Our Ref: M/57/18/HH
Your Ref:

Town & Country Planning Act 1990 (as amended)
Town & country Planning (Development Management Procedure) (England) Order 2015
Application for Planning Permission for Works or Extension to a Dwelling

Development Single storey infill extension, between existing kitchen & garage.
Location 18 Merry End Middleton-On-Sea

LOCATION PLAN 1:1250

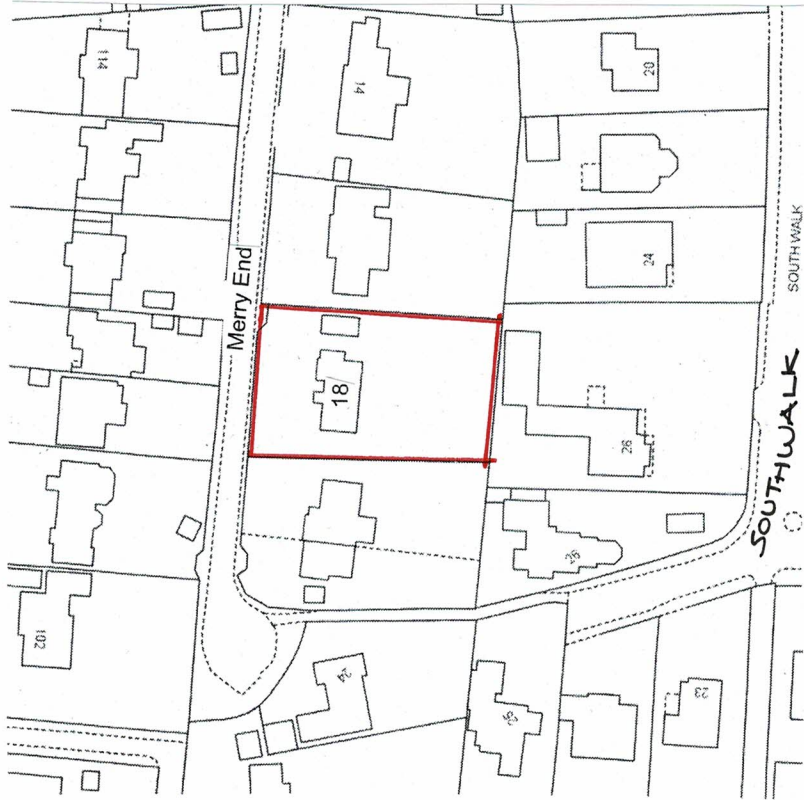
Location Plan - revised

Please submit 1 electronic or 3 paper copies of a revised location plan at a scale of 1:1250 or 1:2500 for rural areas with the addition of another road name clearly indicated. Further details of what must be included on the plan can be found in the National Validation Requirements.
